ADL Traffic and Highways Engineering Ltd

Re: A38 DERBY JUNCTIONS PROJECT: DEADLINE 3 SUBMISSION

1.0 Written Summary of Oral Representation

DELIVERY TRACKS

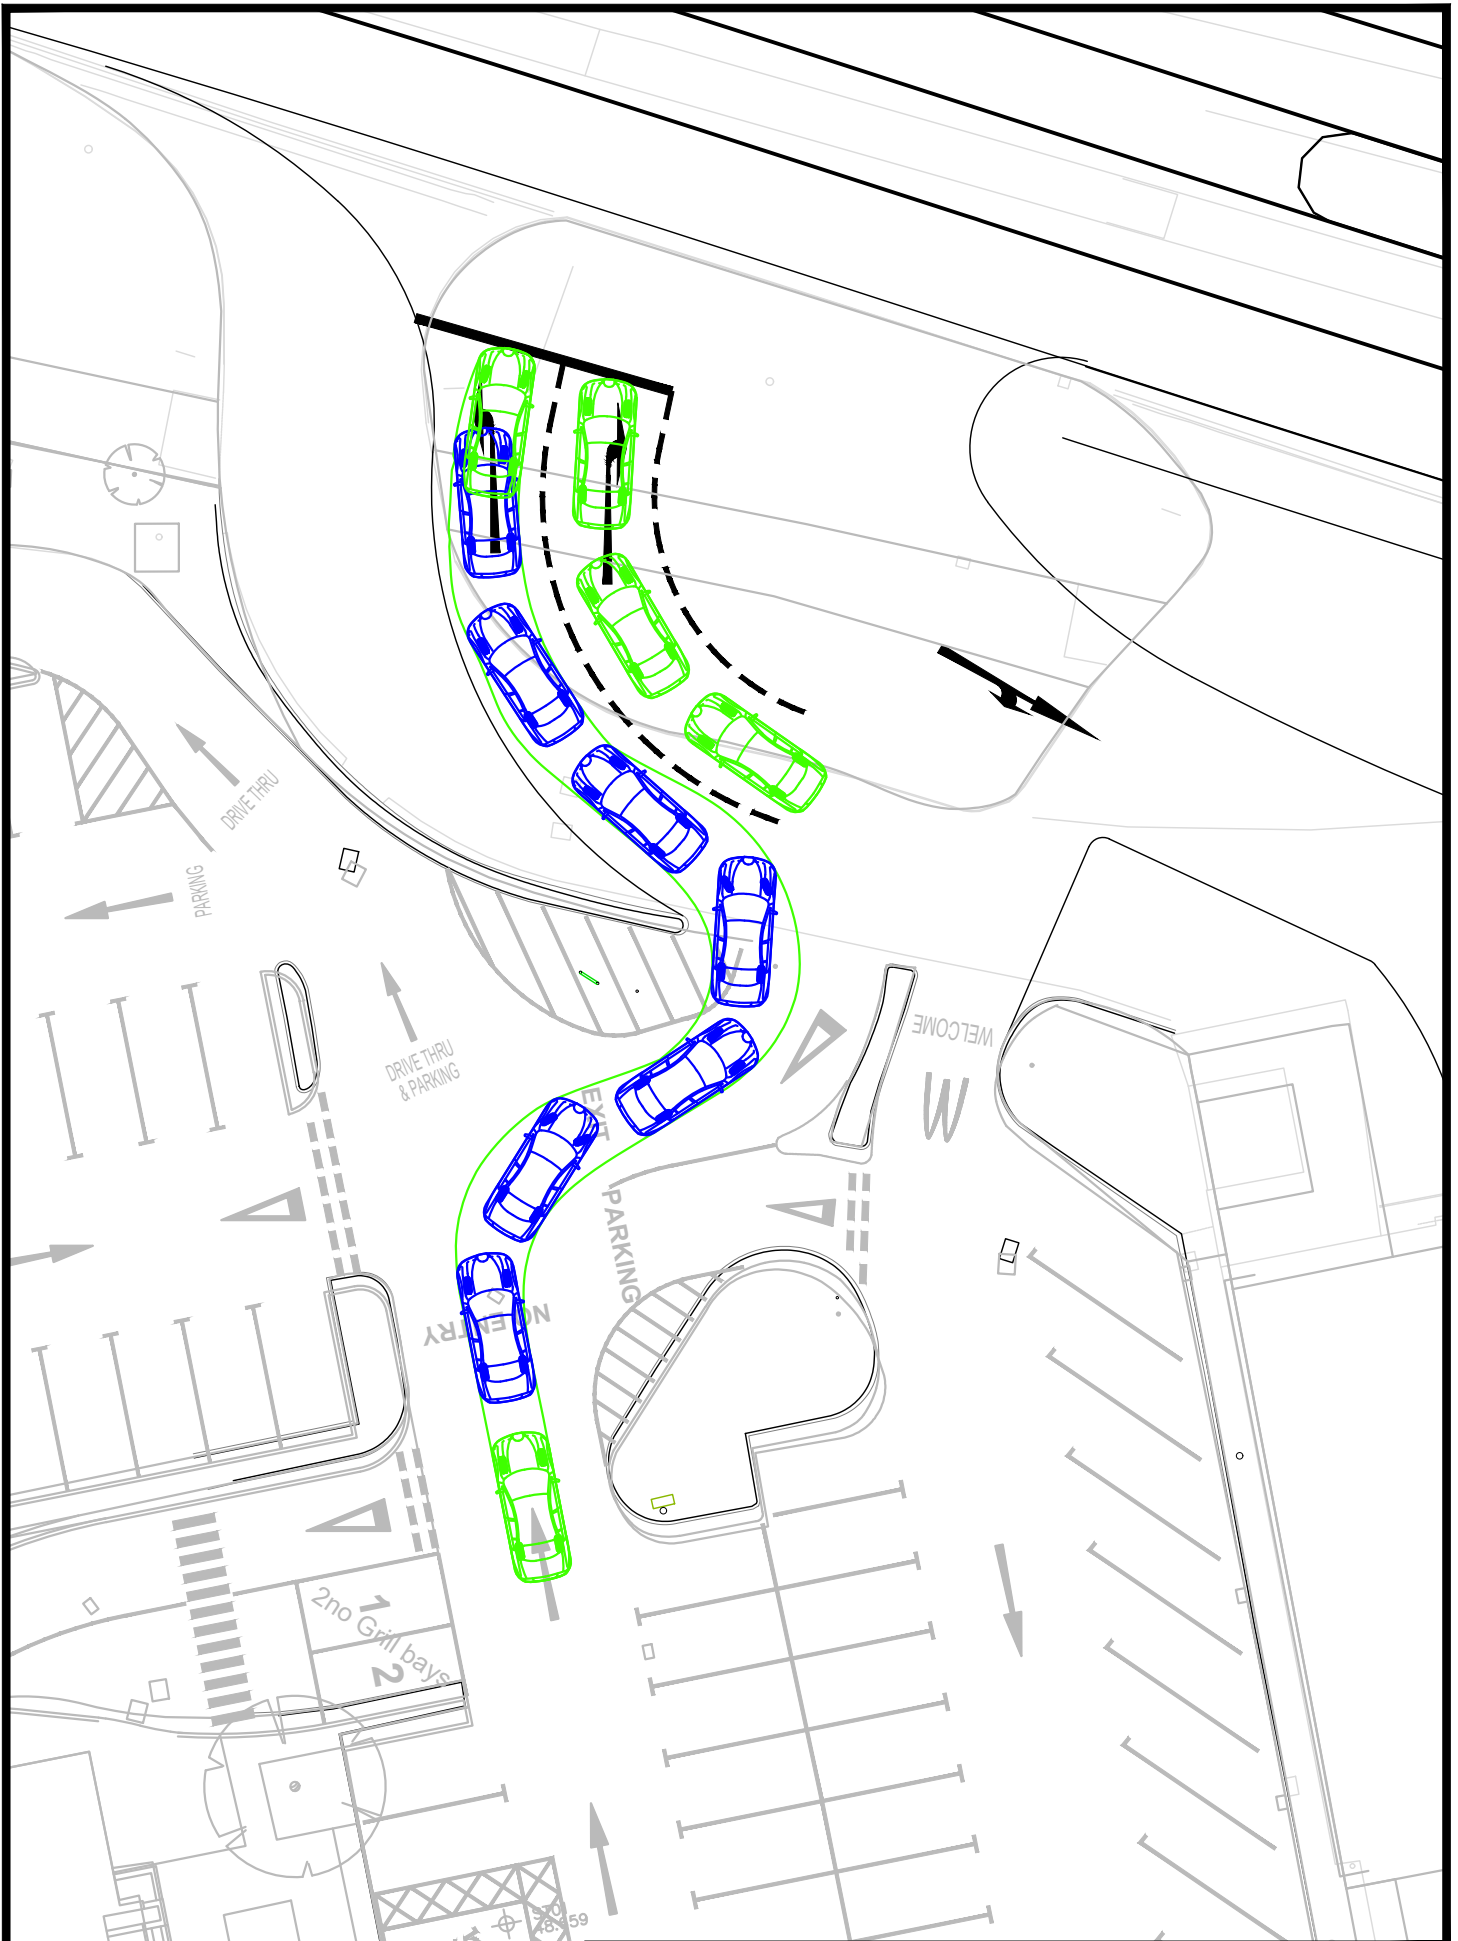
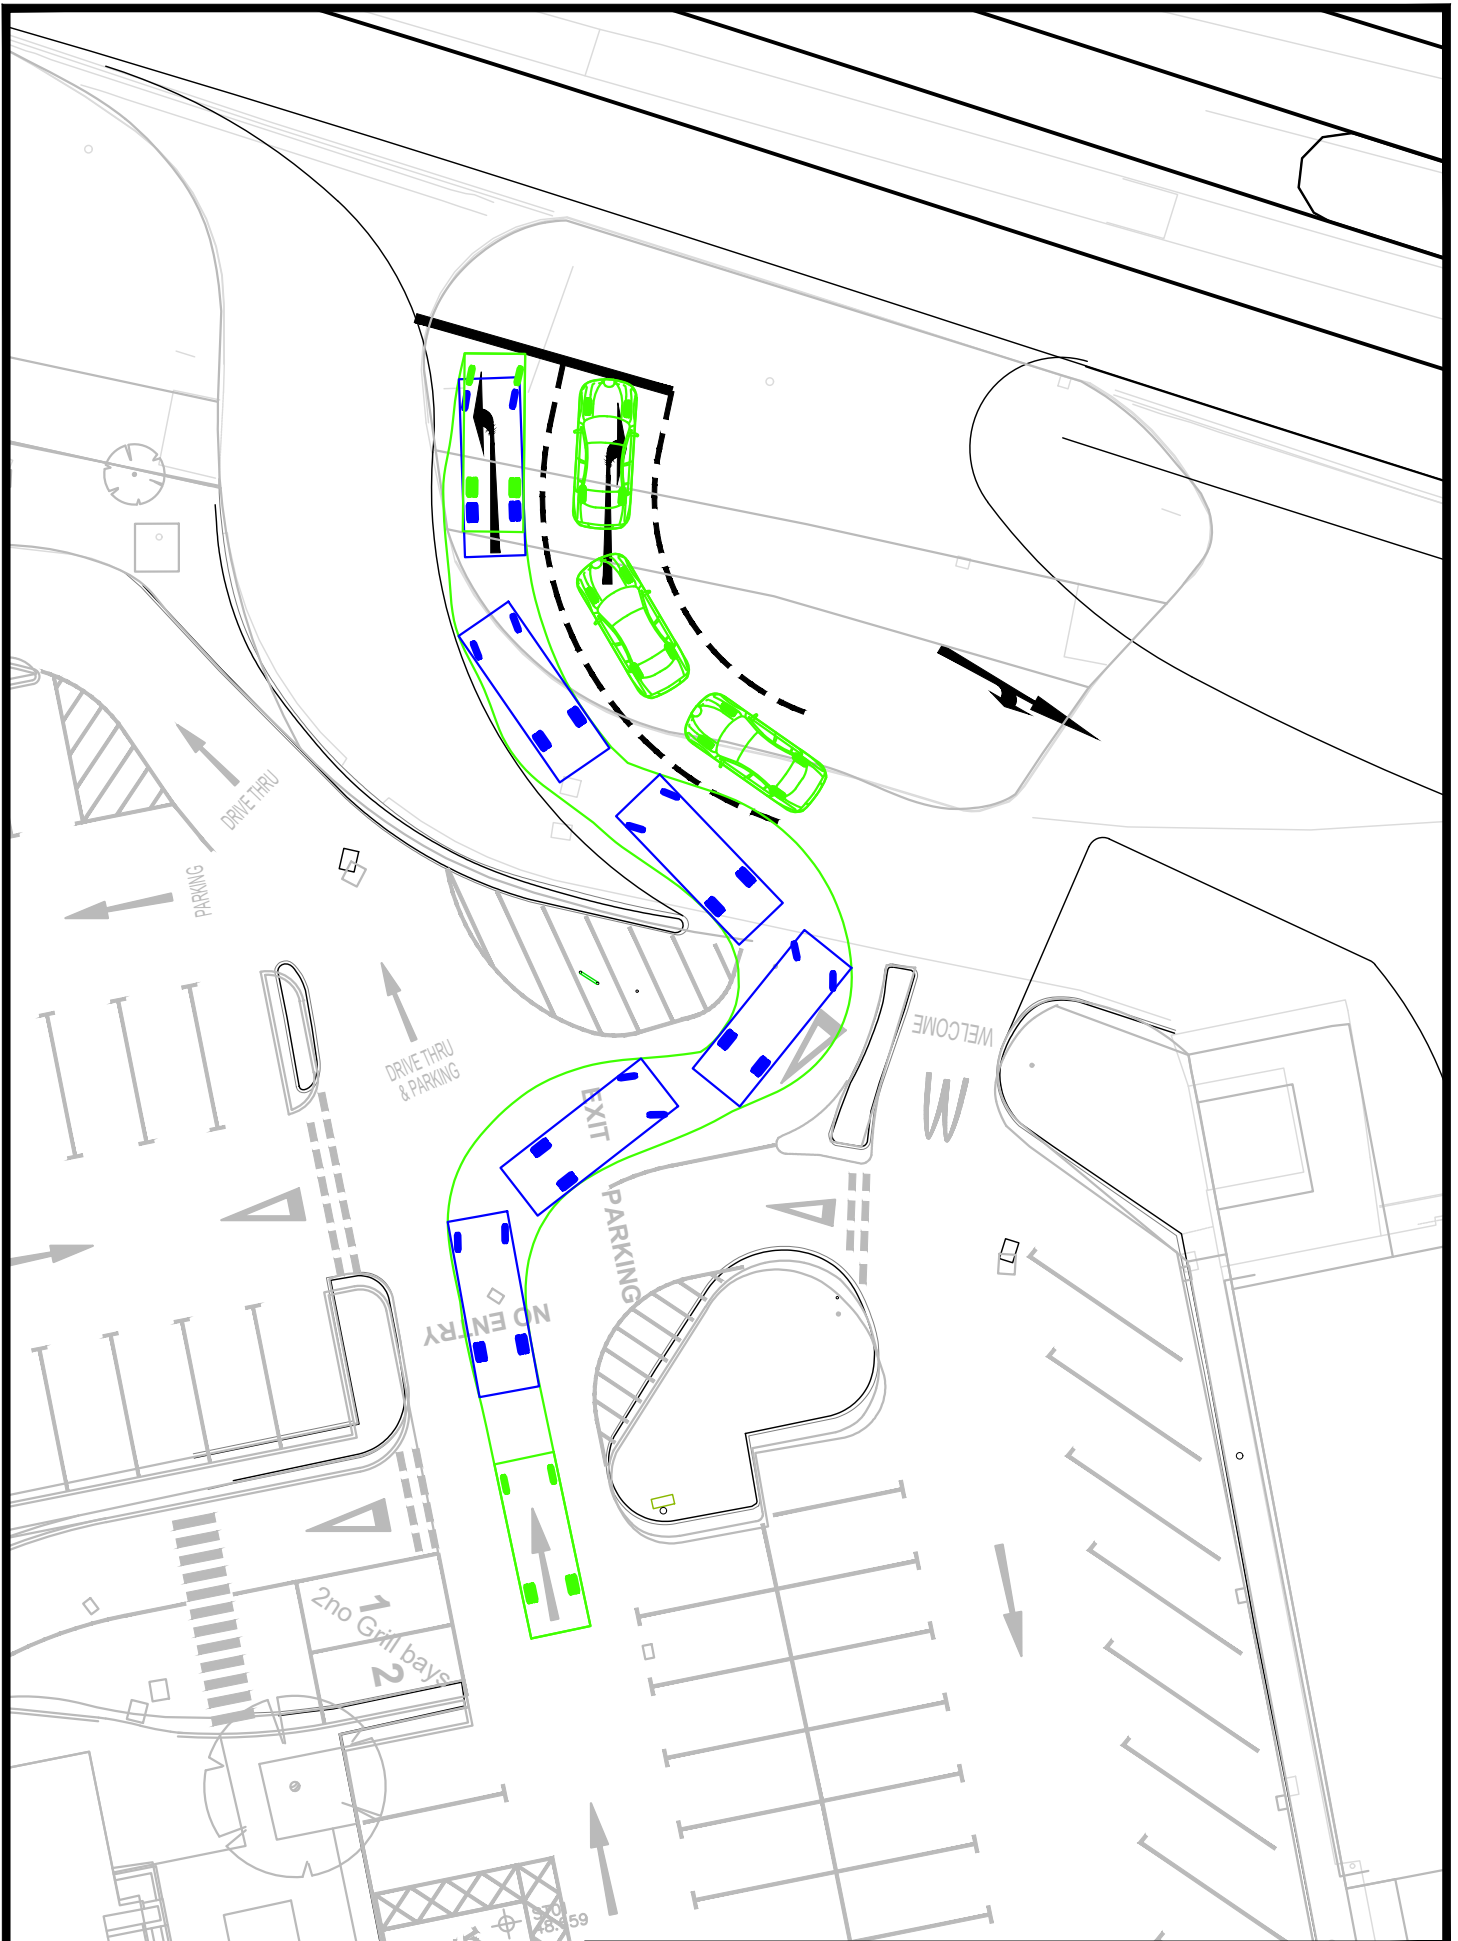
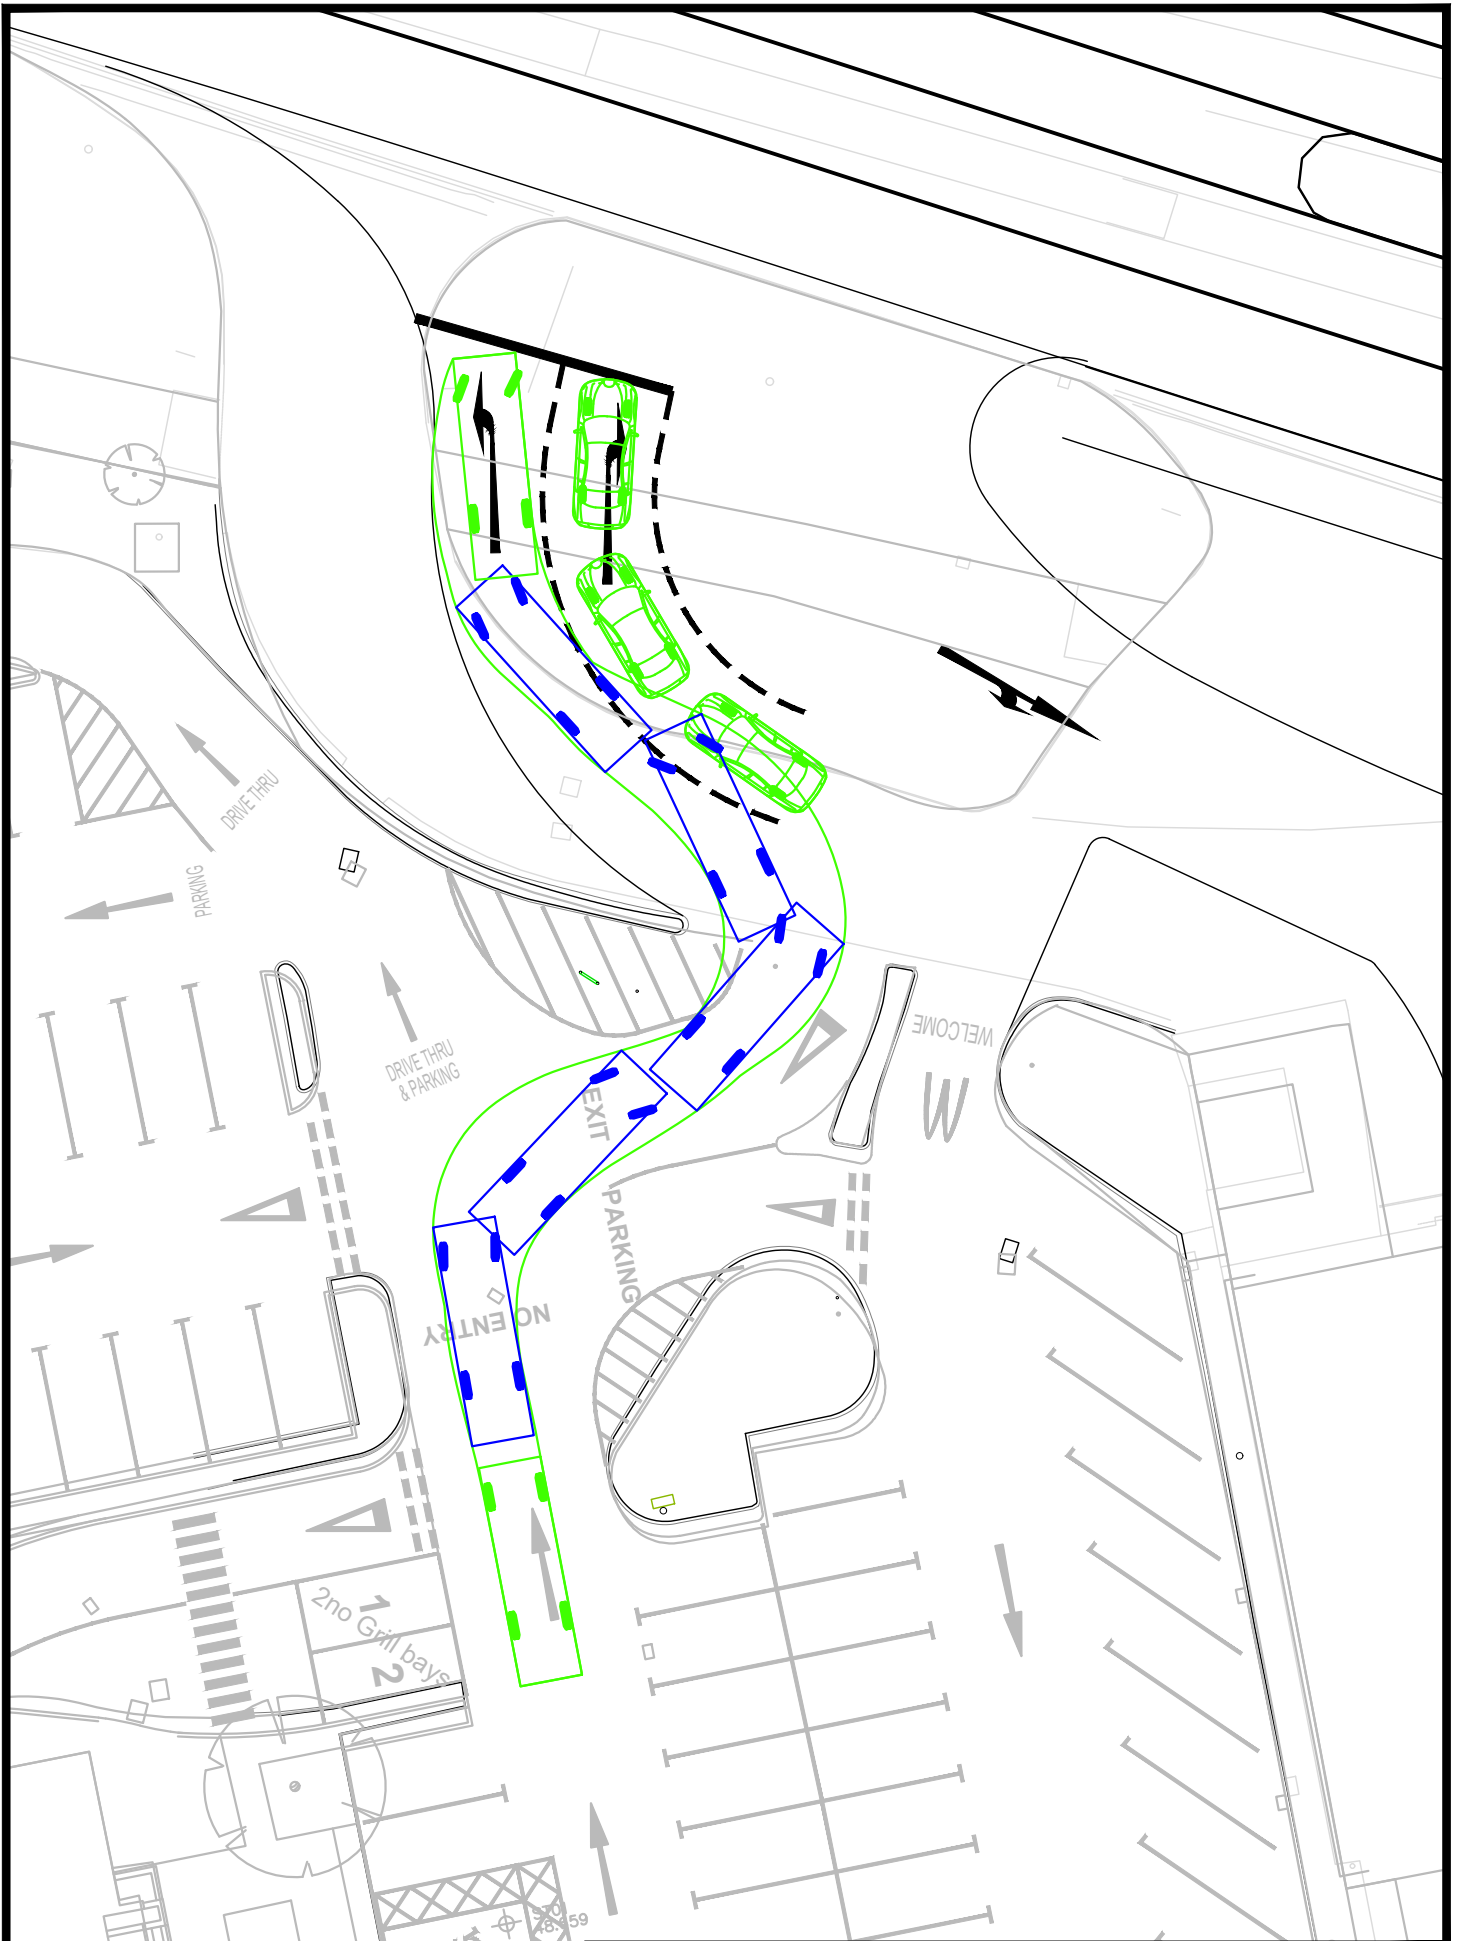
Swept paths were included as Appendices 6.1 and 6.2 of our Written Representation. These show the full size articulated delivery vehicle entering and exiting the site. We note that the left turn into the site from the A52 is very tight and the inside track of the vehicle envelope touches the kerb face during the turn in.

The driver is then required to enter the north end of the McDonald's customer car park and travel south down the parking aisle before turning onto the Euro Garages forecourt. Changes will need to be made to the existing kerbing at the north and south ends of the car park to avoid the HGV overrunning these existing elements. From here the vehicle reverses back to the offload position, similar to the existing situation.

The exit manoeuvre was shown at Appendix 6.2 of our Written Representation and would be as per the existing situation.
